Application No. SSD-47105958

Location: 24A Kingscliff Street, Kingscliff

Table 1 - SSD-47105958 Special Report Reviews and Comments

BUILDING SECTION R1

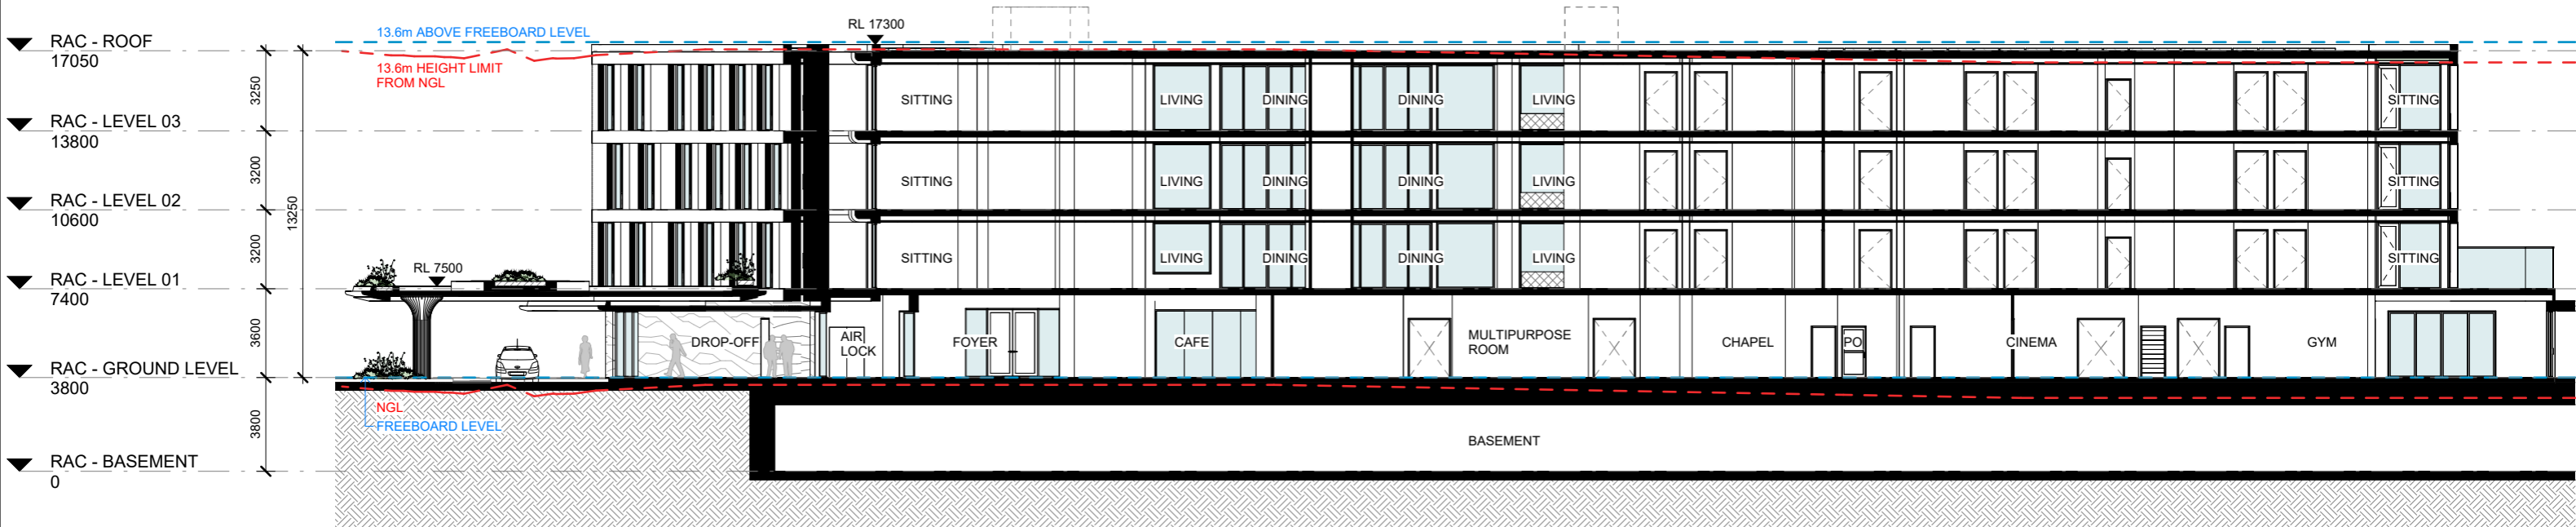
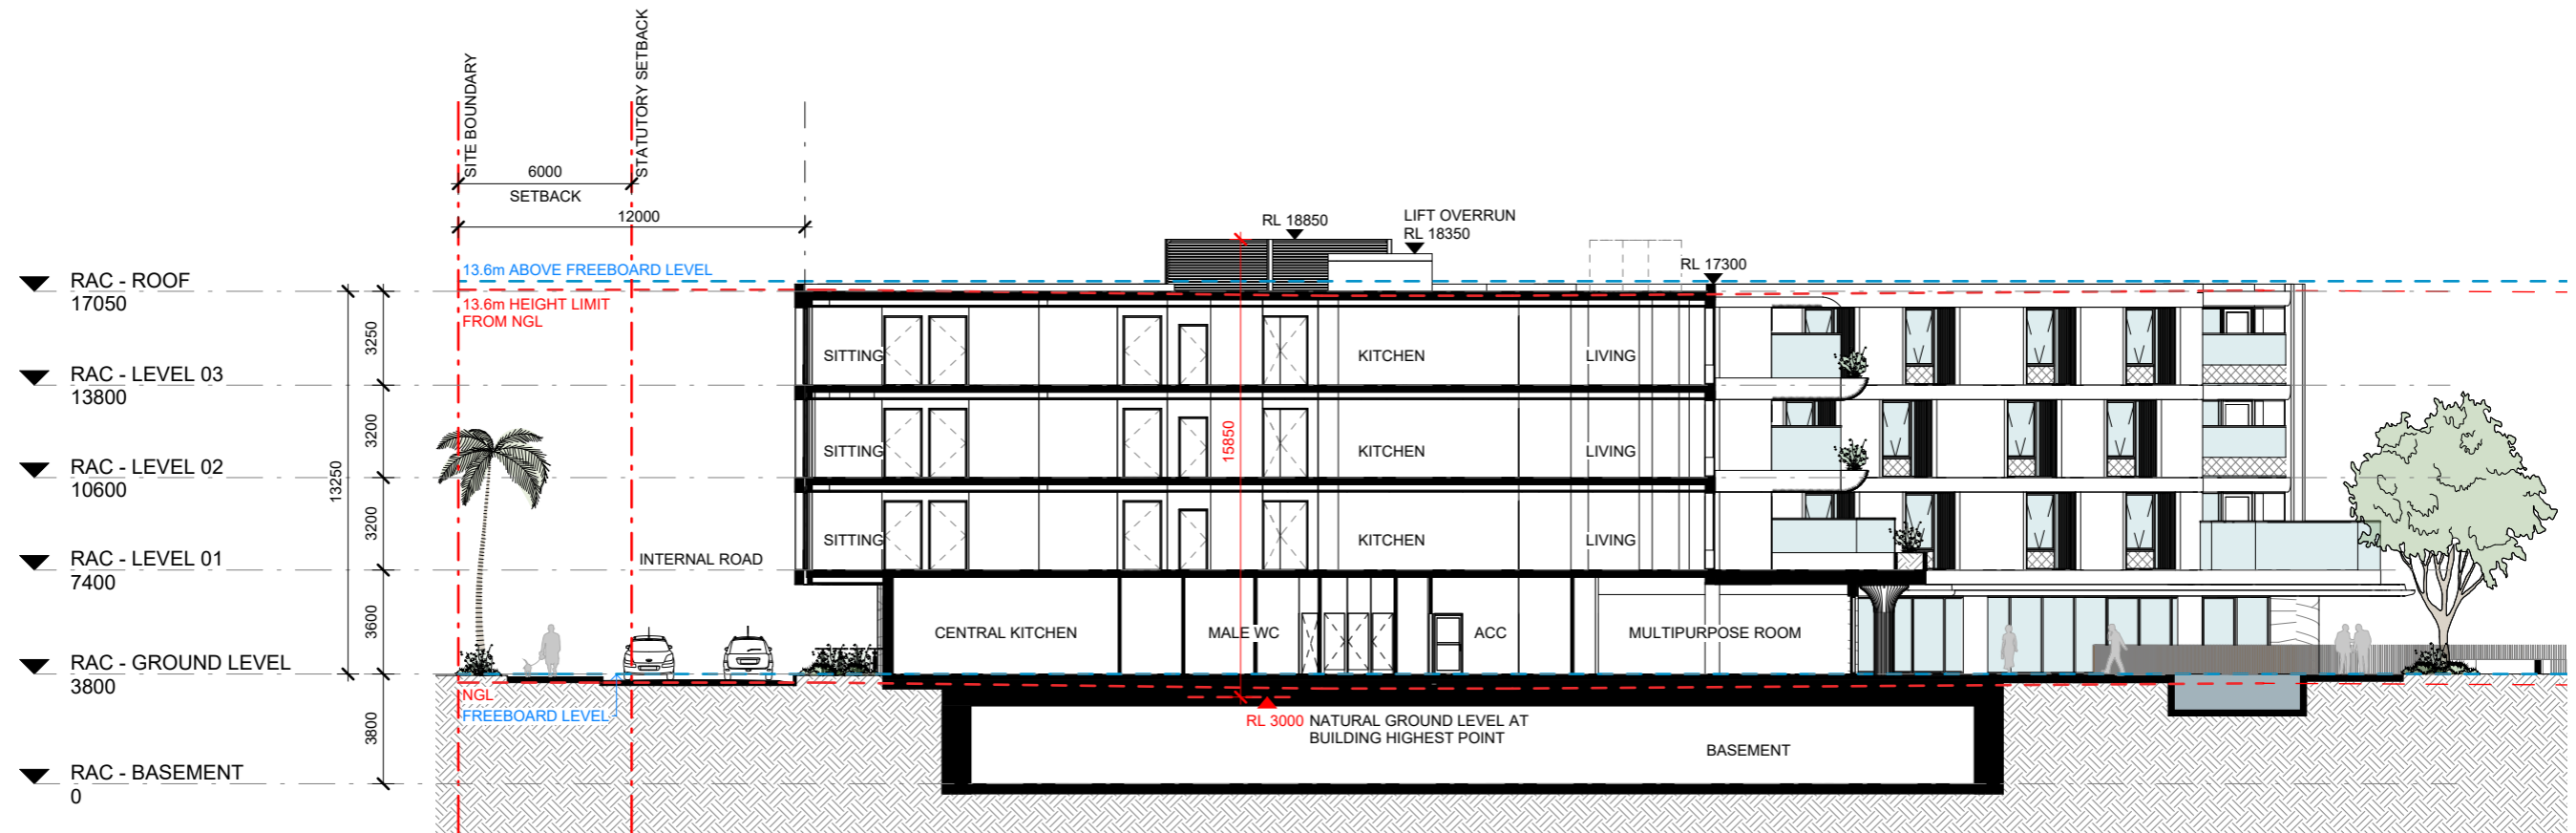
<p>Architectural plan PLDA-200</p>	<p>37. Incorrect Cross Sections and Ground Level Representations</p> <p>The existing ground levels shown on this plan are inaccurate. Refer Survey Plans which indicate existing is 2.9m at interface with norther dwellings fronting Beach Street. The proposal will result in a vertical wall at the basement ramp and along the northern extent to any proposed deep planting. As per flooding that occurred in April 2022 flooding, water will displace directly from the from the subject site into neighbouring properties as a result of this design.</p> <p>Review also Flood Report comments.</p>

SSD Report Source	Issue / Comment	Item / Reference
Architectural Plans - Prepared by Plus	<p>41. Incorrect Cross Sections</p> <p>Cross sections are incorrect with respect to existing levels over the site. Interface with Drift Court is not currently at 3.8m as represented on the plans. These interfaces includes a vertical wall varying from 1.6 to 1.2m in height. These are not shown in the plan set. Basement level will not be under existing ground level and will be ‘sticking up’, constituting a floor when compared to the existing ground level.</p> <p>Cross Section does not show 1.0m drain reserve along interface of 41 Drift and how the proposed development plans to respond to this aspect.</p>	<p>ARCHITECTURAL DRAWINGS PLA-DRW-DA-0301</p> <p>OVERALL SITE</p> <p>SITE SECTION BB & CC</p>  <p>UNITING plus</p> <p>JANUARY 2024 DEVELOPMENT APPLICATION PLUS ARCHITECTURE</p>
Visual Impact Report – Prepared by Ethos Urban	<p>42. Misleading and incorrect Visual Representations</p> <p><u>The visual impact assessment is very misleading and does not accurately depict the true context of the proposed development’s impact on the surrounding area.</u> This includes taking photo points from behind buildings, retaining existing trees that will be removed as part of the development and ‘close-up’ photos from surrounding roads (Beach Street, Drift Crt, Kingscliff St) which purposefully depict existing dwellings as ‘dominant’ buildings in the foreground, minimising the perceived impacts of the proposed buildings. Overall, the Visual Impact Assessment is (either intentionally or unintentionally) misleading and requires significant updates once the final design is revised (based on other non-conformances highlighted in other reports).</p>	<p>Reference photo locations and inclusions below</p>
